PLANNING CONSULTATION RESPONSE

Application No	2026/0599 & 0600
Proposal	2026 0599 & 0600 Subdivision and C of U for Office and Laundrette with Four Studio Apartments and Assoc Internal Alterations with Revised Access Frontage Arrangements (Retrospective) 8 Regent Street
Address	8 Regent Street Barnsley
Date of Consultation Reply	050826
Consultee	Tony Wiles Senior Conservation Officer

Proposed First Floor Plan
scale 1:50

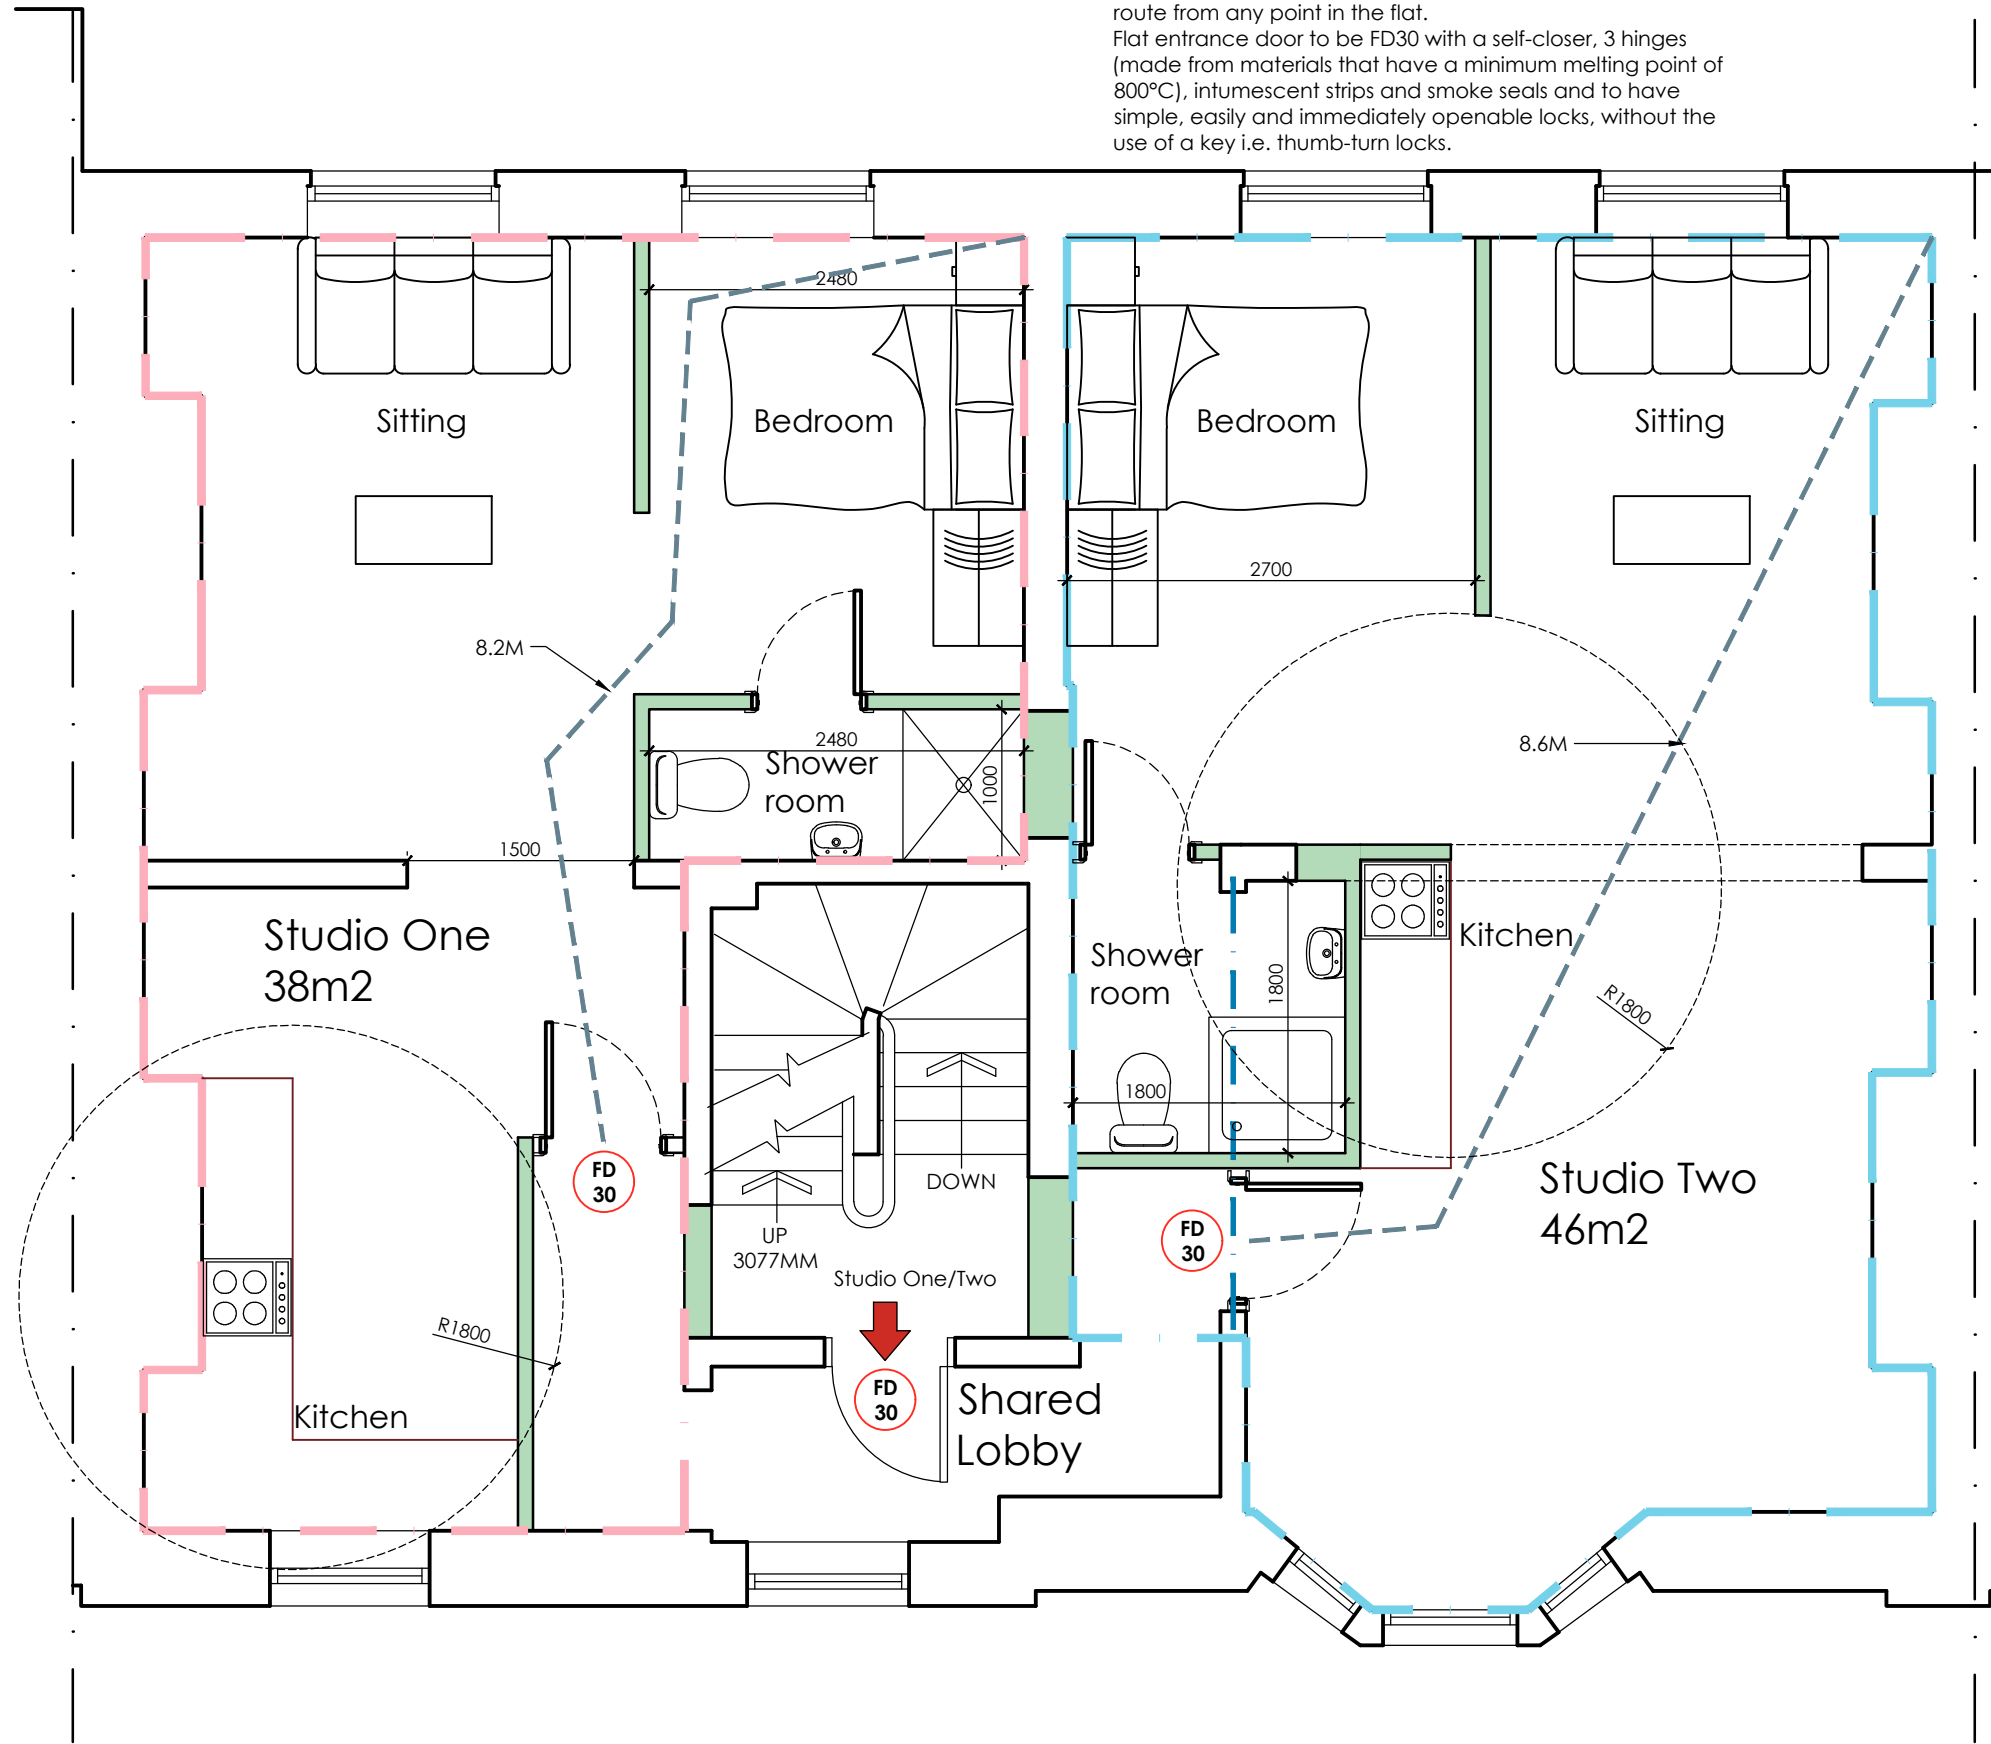
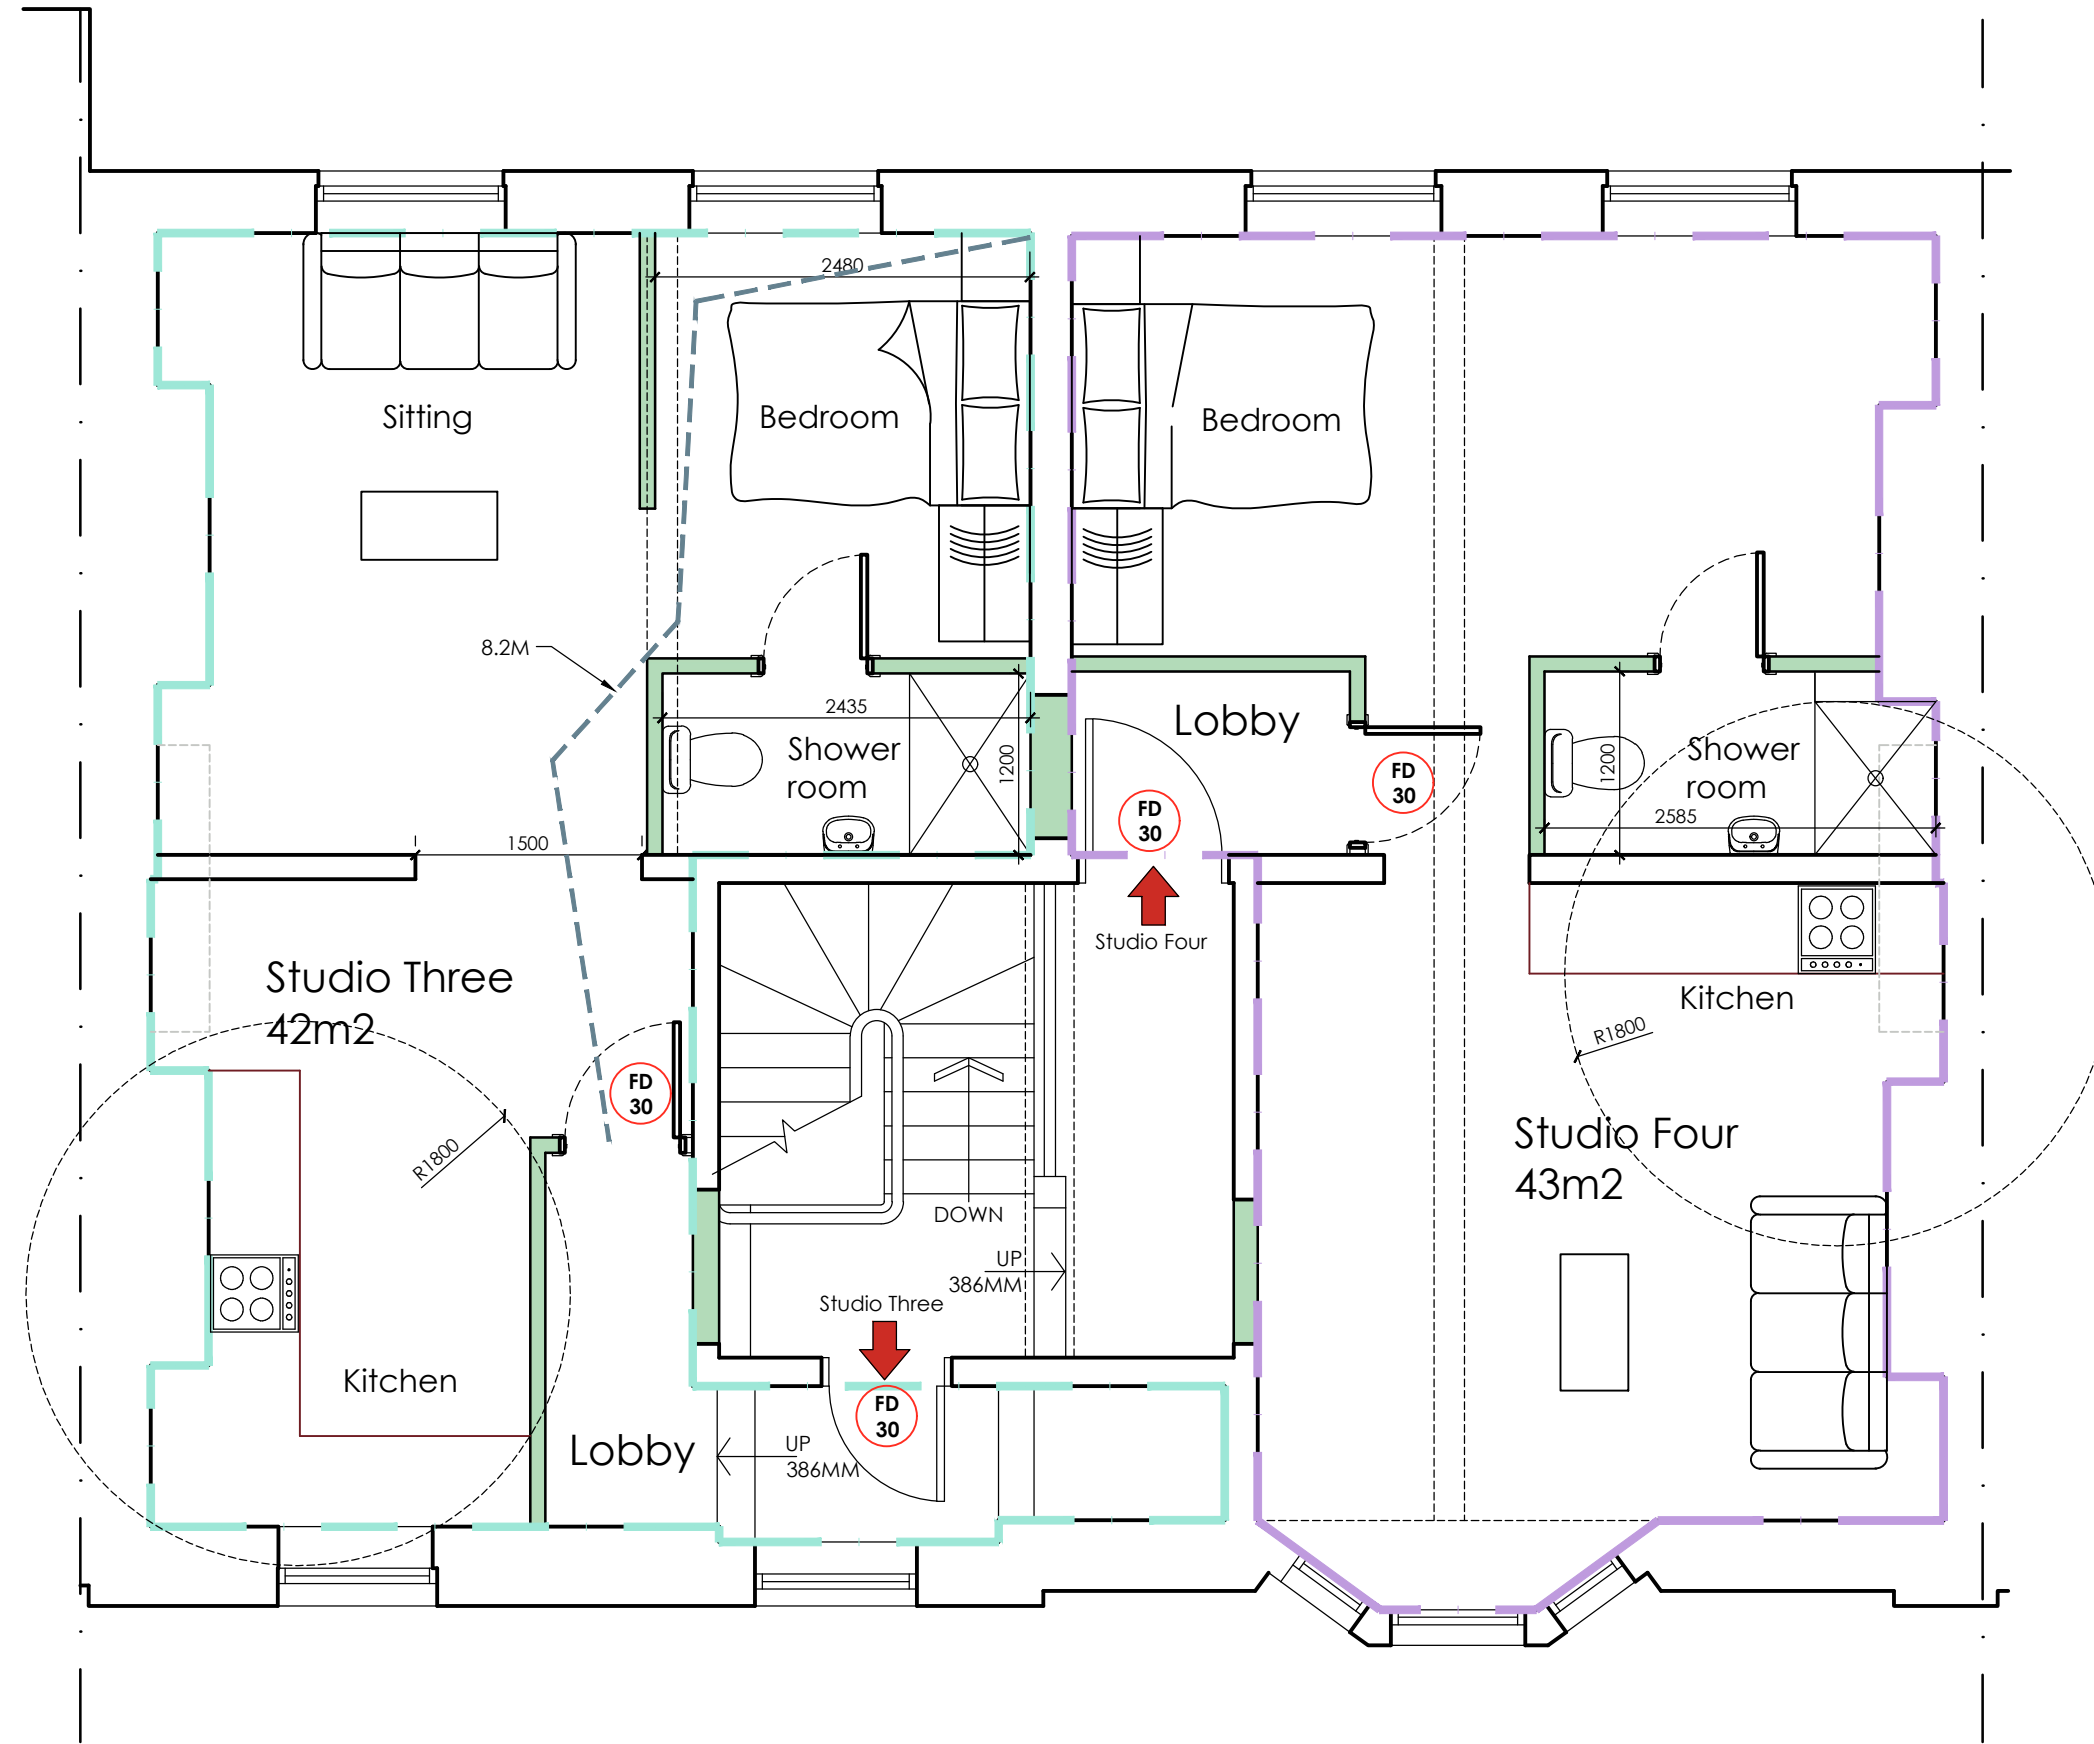
No external works or basement-level alterations are proposed. The applicant states that no significant historic features are proposed to be removed, with the works principally comprising internal subdivision, fire and acoustic separation, and alterations to form the office and laundrette lobbies, residential entrance, and four studio apartments. Minor frontage and access alterations were originally proposed, but the submitted plans have now been updated to omit these. At ground floor level, two lightweight stud lobbies would be formed either side of the entrance hall after entering through the front door, providing independent access and, I presume, fire separation. To the rear of the building, a communal bin store would be created. A similar bin store arrangement was approved in 2024. At first and second floor levels, the existing stairwell access to the side offices would be blocked up and replaced with a shared lobby at the front of the building on both floors. These lobby areas would be formed within spaces currently occupied by W.C.s at first and second floor levels. Elsewhere, the studio flats would be created by closing off the existing interconnecting doorways which currently allow access across the floors, together with further lightweight stud partitions to provide toilet and shower rooms. Each flat would be arranged in a generally open-plan manner. Overall, the internal interventions are relatively light-touch and appear largely to affect modern fabric or later alterations which do not make a strong or positive contribution to the historic significance of the listed building. On that basis, I support the principle of the proposal; however, there are some matters which require clarification or amendment. I note the proposed removal of the structural wall at first floor level between Studio 2 and the shared lobby. This appears to be an original structural wall, and its removal would be a more intrusive intervention. It would introduce a minor degree of harm to the historic fabric and would erode the original plan form and layout. I would therefore suggest that the scheme is amended to avoid this intervention, or that a clear and convincing justification is provided to explain why it is necessary, beyond the general requirements of the conversion to apartments. I also note the proposed removal of the dividing wall between existing office rooms 5 and 6 to create the open-plan space for Studio 2. It is not clear from the information provided whether this is a stud partition, a later subdivision, or historic fabric, and this point requires clarification. I also anticipate that the conversion of the ground-floor unit to a laundrette will require signage. While I do not object in principle to the change of use of the space, any signage will need to be restrained, compatible with the quality and character of the listed building, and accommodated within the constraints of its architecture, as set out in the informative below. Finally, while the plans do not appear to indicate its removal, I would ask for confirmation that the three-centred downstand and moulded arch, together with the adjacent guardrail, newel post and balusters at the head of the second-floor stair, will be retained as existing.

Following clarification from the Agent, I understand the dividing walls penned for removal or alteration are timber studs and later modern partitioning. I also understand the balustrade and arch mentioned above are to be retained unaltered.
